M54 to M6 Link Road TR010054

8.8 LIU(E) Statement of Common Ground with Mark Commins & Tracey Commins

**8.8 LIU(E) Statement of Common Ground with
Mark Commins & Tracey Commins**

STATEMENT OF COMMON GROUND

FIGURE 11.4
SHORT TERM CHANGE IN
TRAFFIC NOISE LEVELS
(DM2024 TO DS2024)

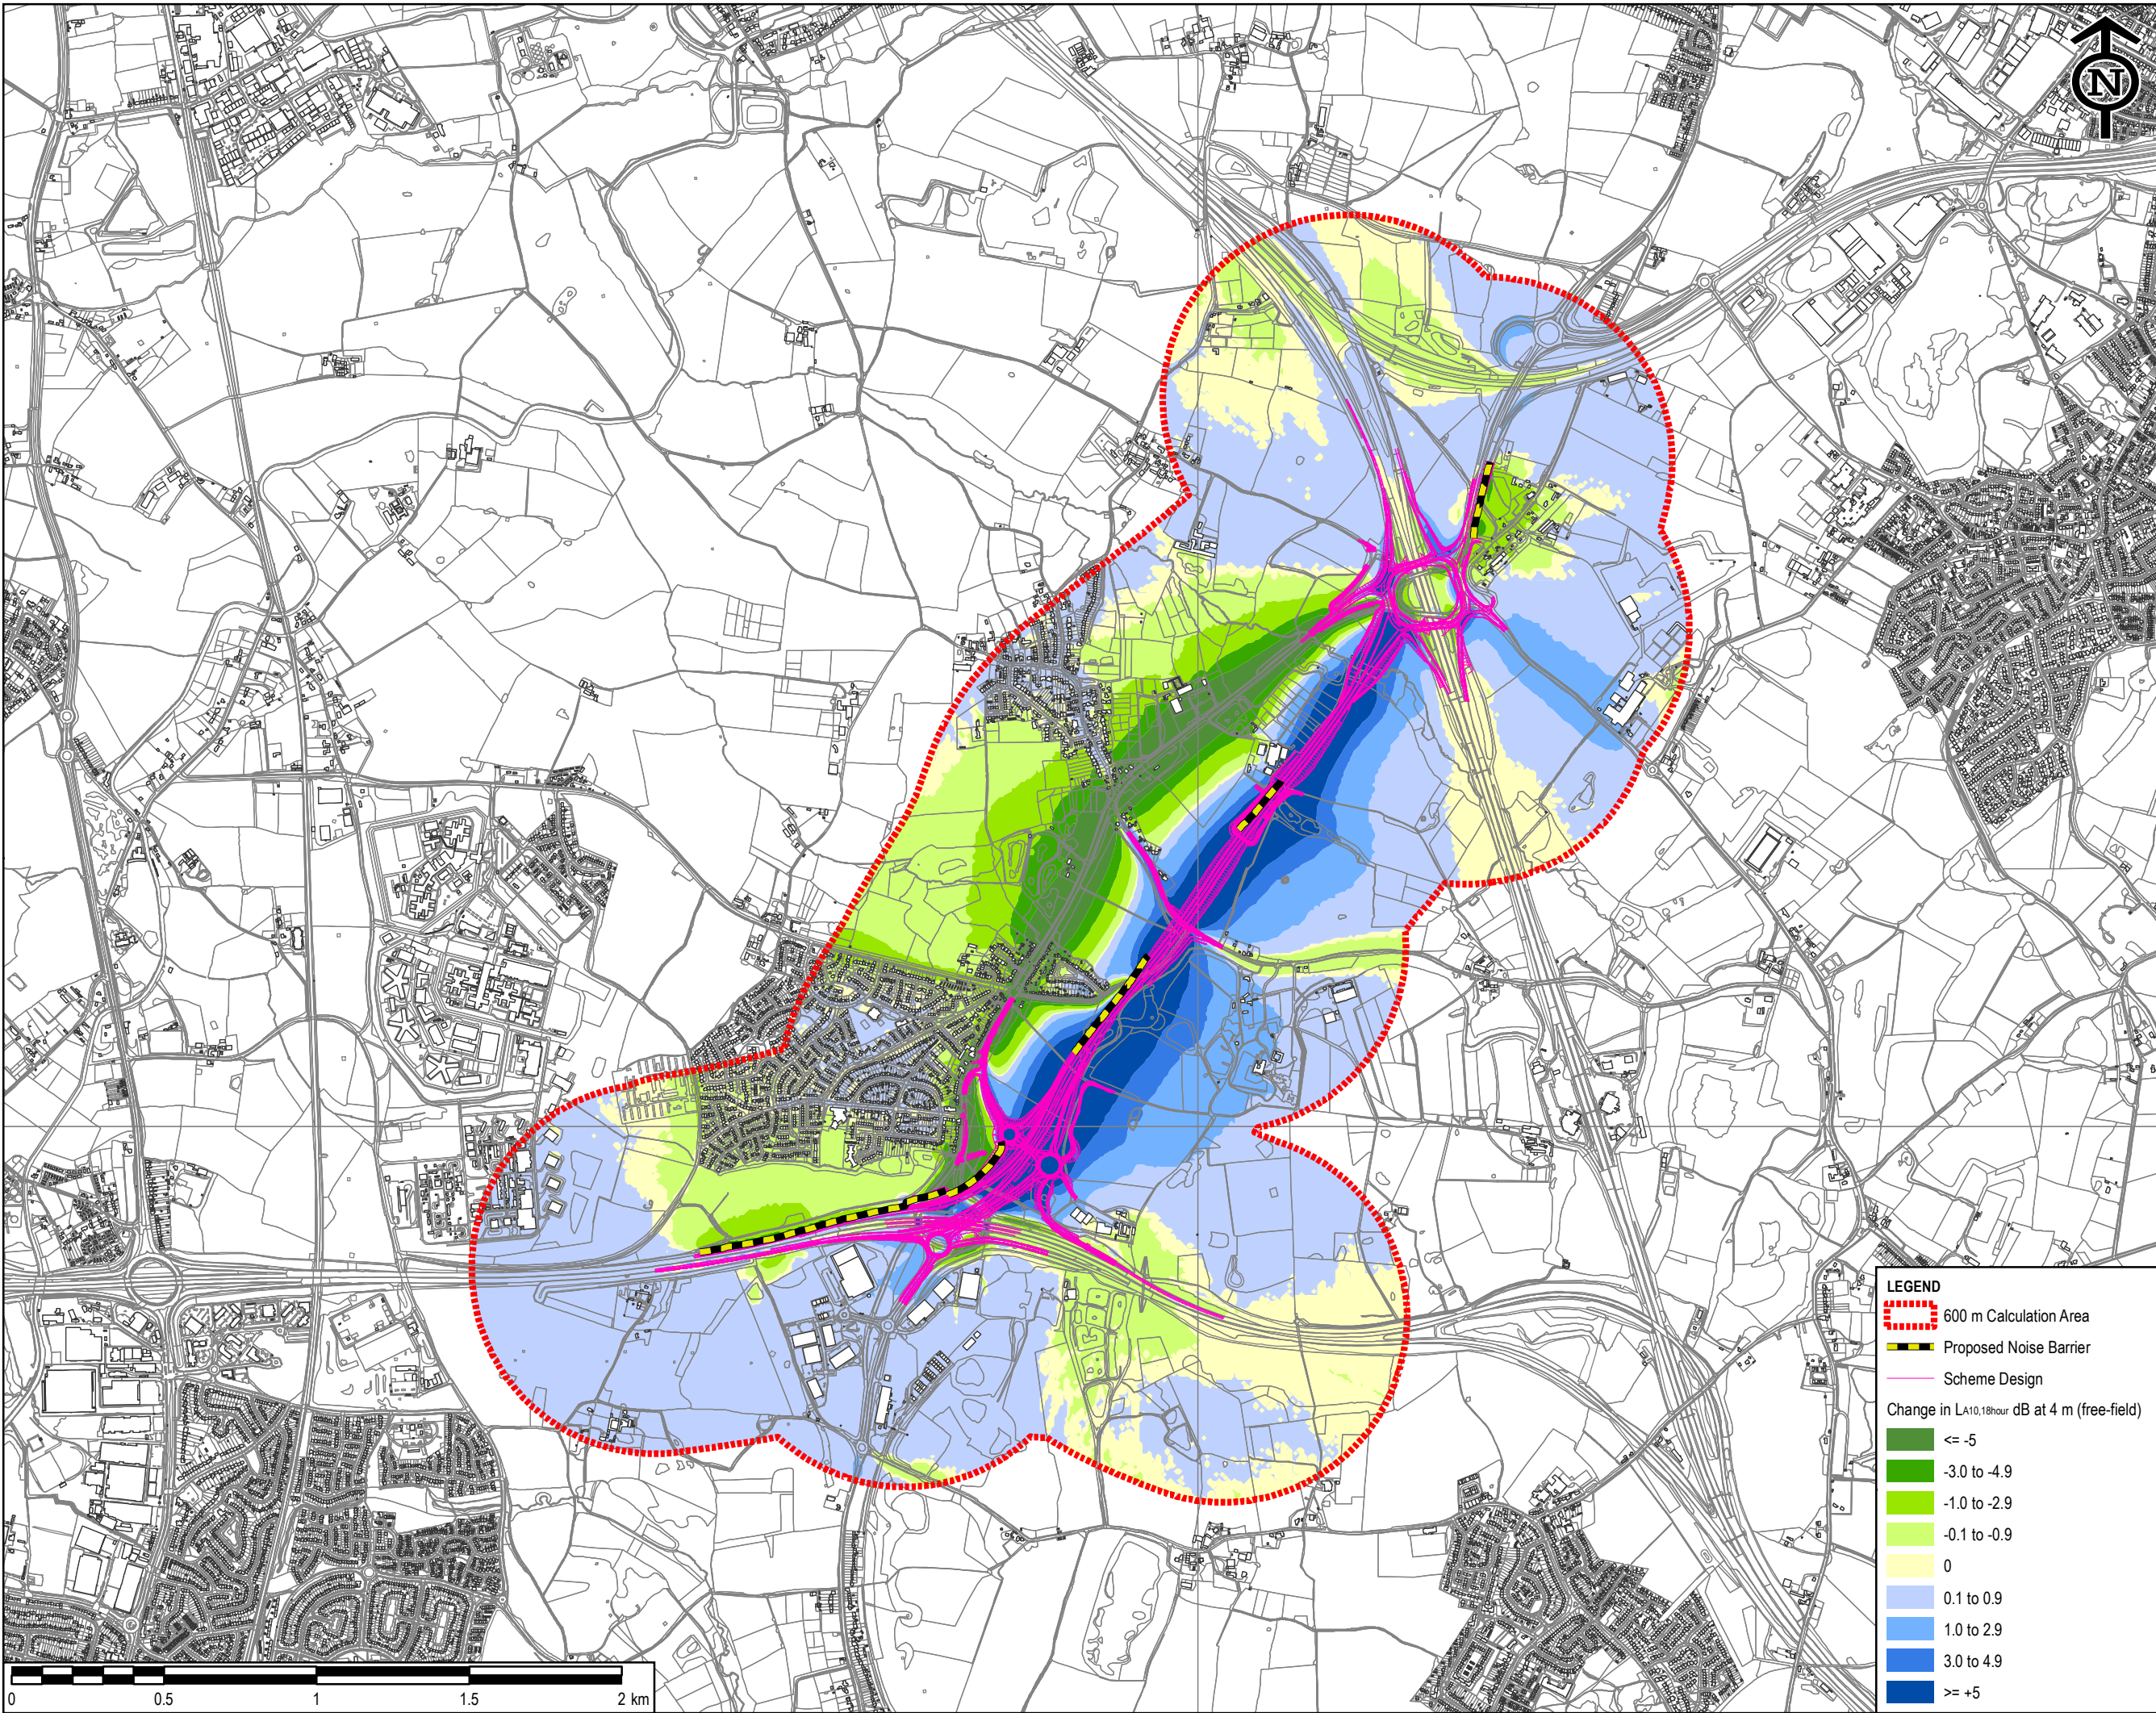
Issue	Landowner comment	Highways England Response	Status	Agreement likely ¹
		boundary and the back of the existing track. Consequently, the existing access track will be unaffected by the works and can continue to be used as per the current scenario. Highways England will continue discussions with the Landowner to ensure this remains the case.		
Proximity between highway realignment and fishing pool	Concern regarding the 3 metre proximity between the realigned A460 and fishing pool and the potential adverse impact on mental health and relaxation of Brookfield Farm customers	<p>The A460 will only be realigned to the North-East of the watercourse that crosses the A460. As this watercourse runs to the north of the fishing pool there would be no realignment of the carriageway in the vicinity of the pools.</p> <p>The 3 metre proximity referred to in the above response is in relation to the edge of land take required to the track, not from the highway boundary.</p> <p>Historically a strip of land was required alongside the ponds to allow for any changes in earthworks, however, Highways England is seeking to minimise works in this area as part of detailed design. Flexibility is required in the DCO to ensure the Scheme is deliverable so no changes can be made to the Scheme as presented at this stage.</p> <p>Figure 11.4 of the Environmental Statement [AS-098/6.2] illustrates the anticipated change in traffic noise levels due to the</p>	Agreed	Agreed

Issue	Landowner comment	Highways England Response	Status	Agreement likely ¹
		operation of the Scheme in the opening year (2024). This illustrates how the change varies across the fishing pond from a reduction in traffic noise levels of around 5 to 7 dB (LA10,18h) at the western side of the fishing pond adjacent to the existing A460, which undergoes a large reduction in the volume of traffic, to an increase in traffic noise of around 4-7 dB (LA10,18h) on the eastern side of the fishing pond adjacent to the new link road. Therefore, the impact of the Scheme varies from beneficial to adverse across the fishing pond, with the magnitude of the increases and decreases being fairly comparable.		
Position of new balancing ponds, outfall locations and water quality	Query the quality of water discharged into the watercourse and water treatment system for adjoining balancing pond including the location requirements for the proposed balancing pond	<p>Measures will be included in the design to ensure that the discharge water quality meets the required standard set out in the Water Framework Directive; this includes features such as Penstock Valves to protect downstream water bodies in the event of a spillage.</p> <p>The pond has been located to the west of the link road due to the direction of flows (to the west). The balancing pond is located at</p>	Agreed	Agreed

Drawing Title
**FIGURE 11.1
 NOISE LOCATION PLAN**

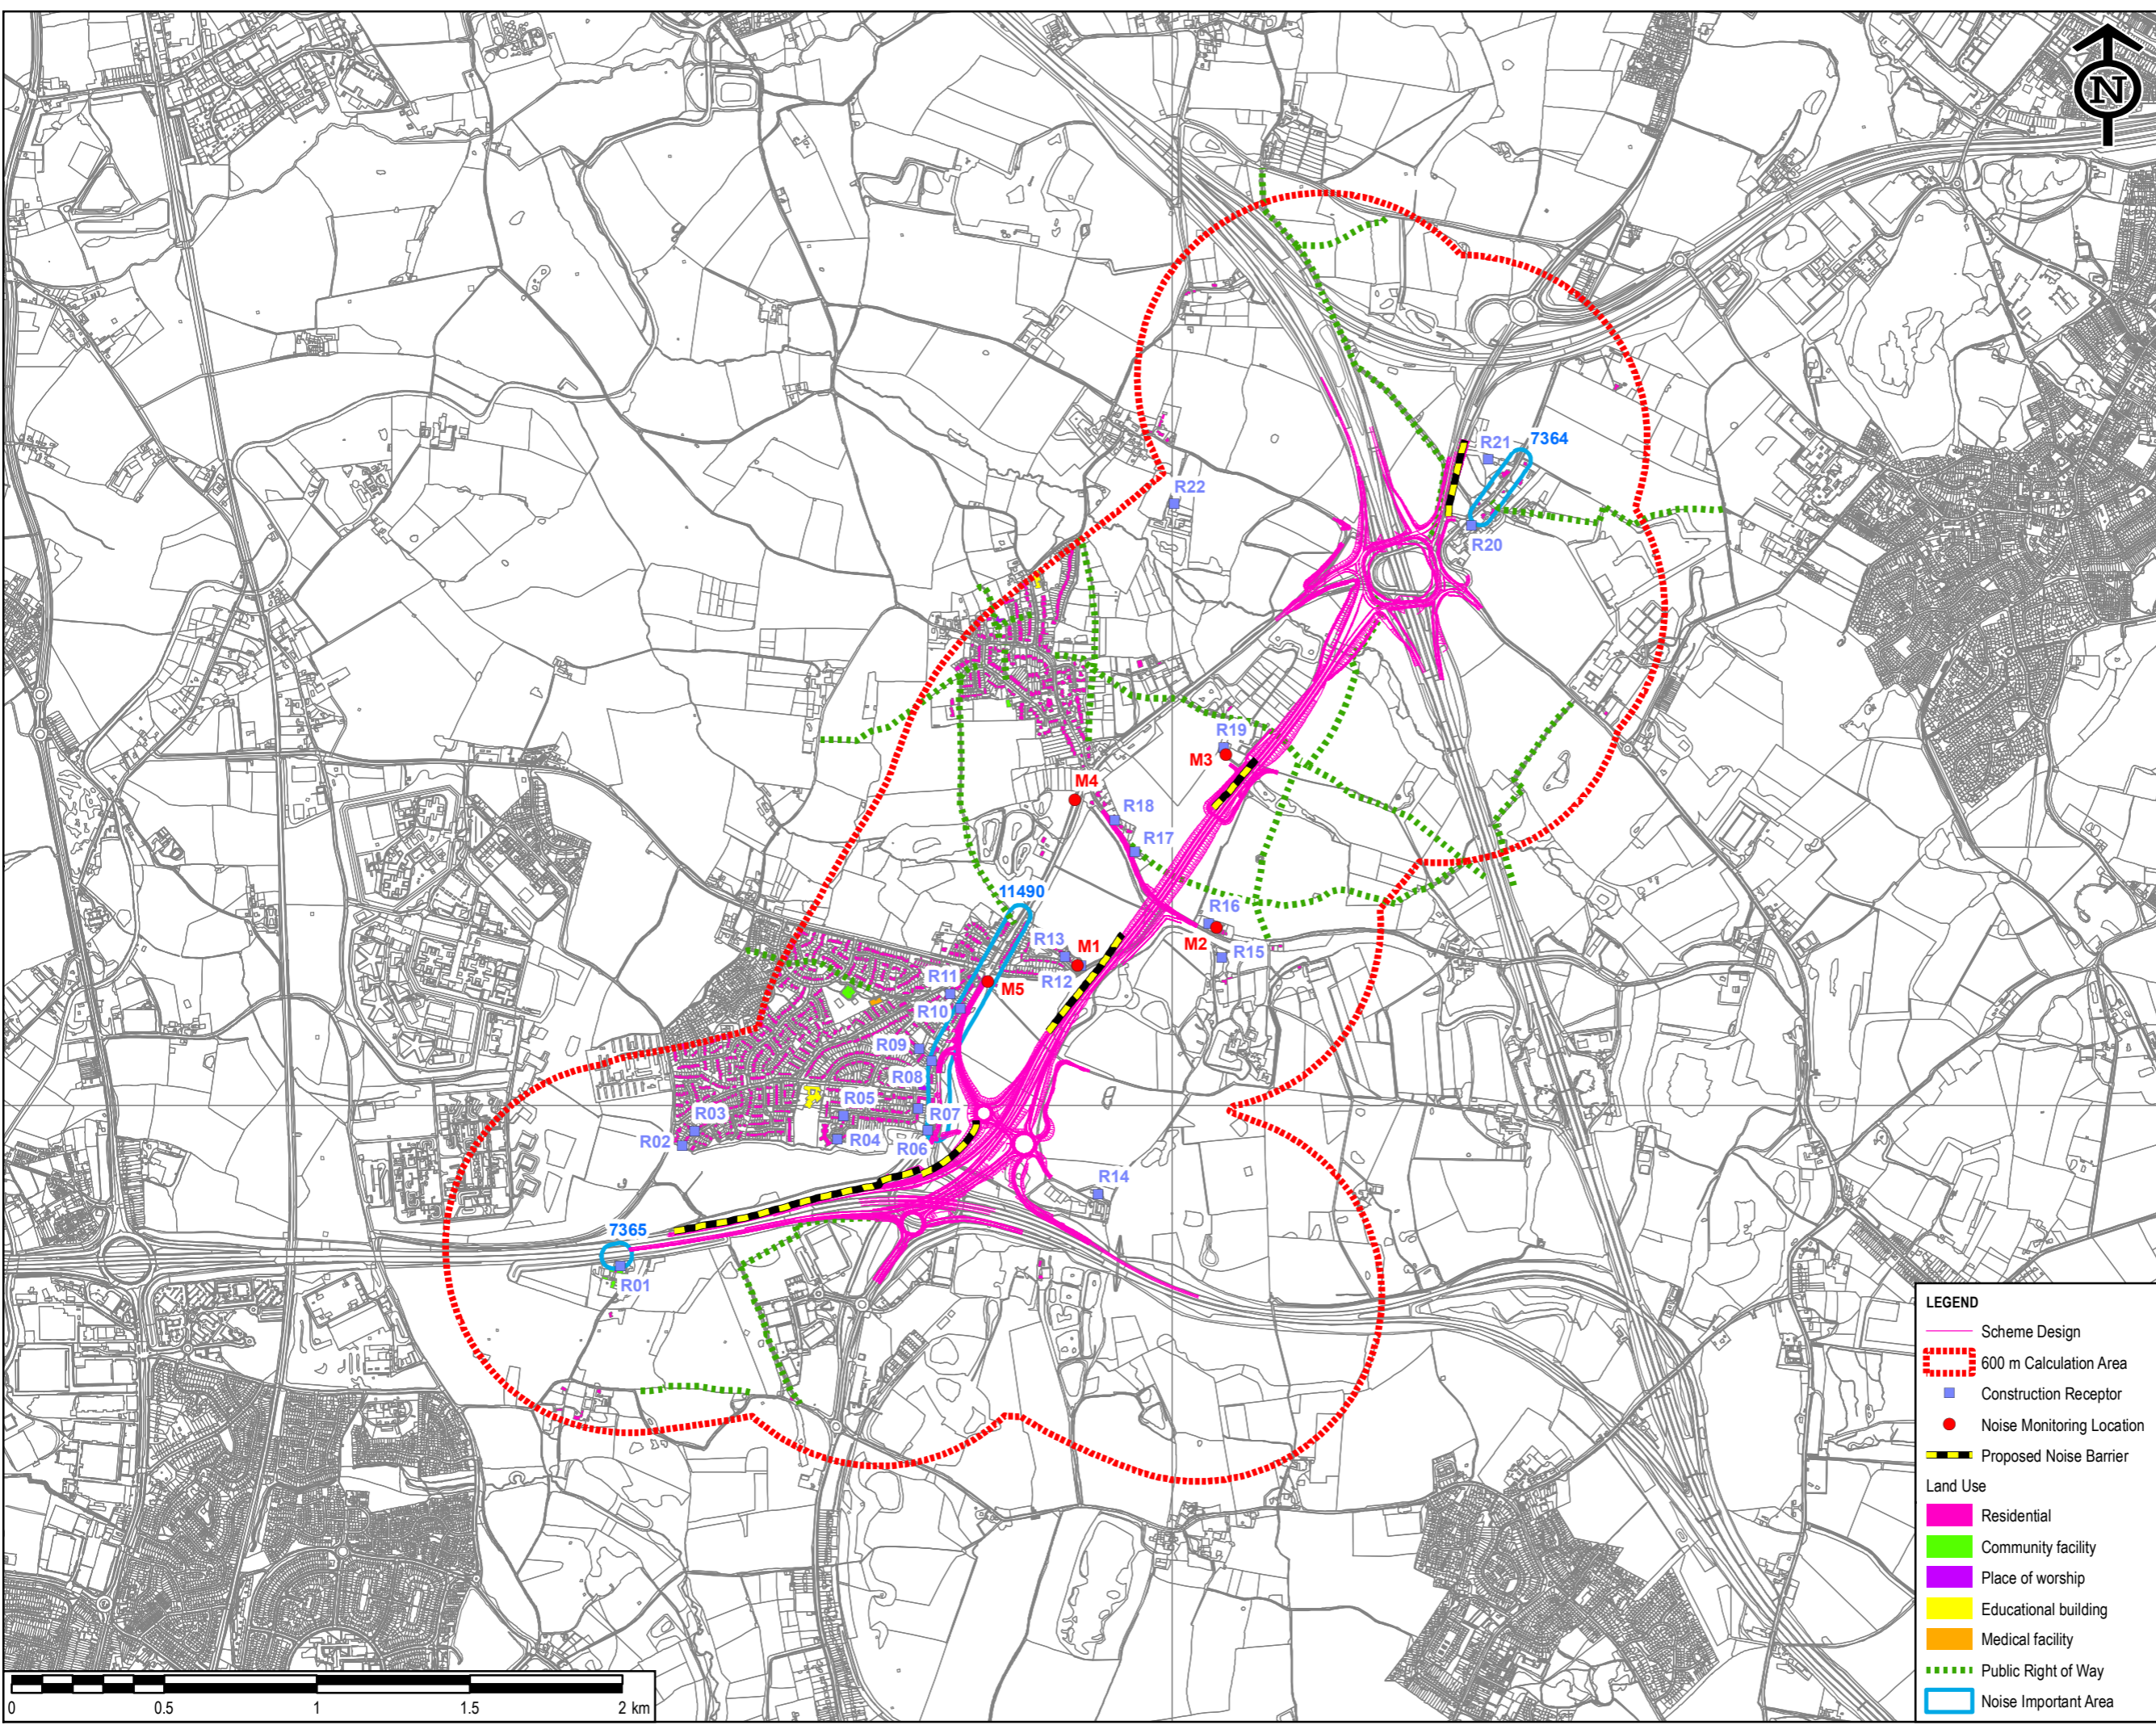
Noise monitoring	Question raised why noise monitoring surveys were not conducted from the club house	Noise monitoring has been undertaken as part of the Environmental Impact Assessment and the results are reported in Figure 11.1 of the Environmental Statement [TR010054/APP/6.2]. The noise monitoring is used to develop an understanding of the general noise climate in the vicinity of the Scheme, and as part of a validation exercise for the prediction model; it is not	Agreed	Agreed

Issue	Landowner comment	Highways England Response	Status	Agreement likely ¹
		used to establish baseline conditions for individual receptors. The traffic noise levels and any subsequent change in the traffic noise levels as a result of the Scheme are then predicted using the model. In order to quantify traffic noise, Highways England would normally want to avoid siting monitoring equipment near specific known noise sources which might distort the numeric results (e.g. a building which may generate entertainment noise).		
Air quality impacts	Air quality assessment at Brookfield Farm	Based on the affected road network, sufficient monitoring data is available from Highways England and local authority sources to confirm the model performance, without the need for further monitoring at this stage of the design. The assessment on air quality in Chapter 5 of the Environmental Statement [TR010054/APP/6.1] demonstrates that no properties will experience air pollution levels above national air quality objective values post construction as a result of the Scheme. The significant reduction in traffic along the A460 will potentially enable future improvements to the road for pedestrians and cyclists, improve the environment around the road and may contribute positively to the identity of these villages along the route.	Agreed	Agreed
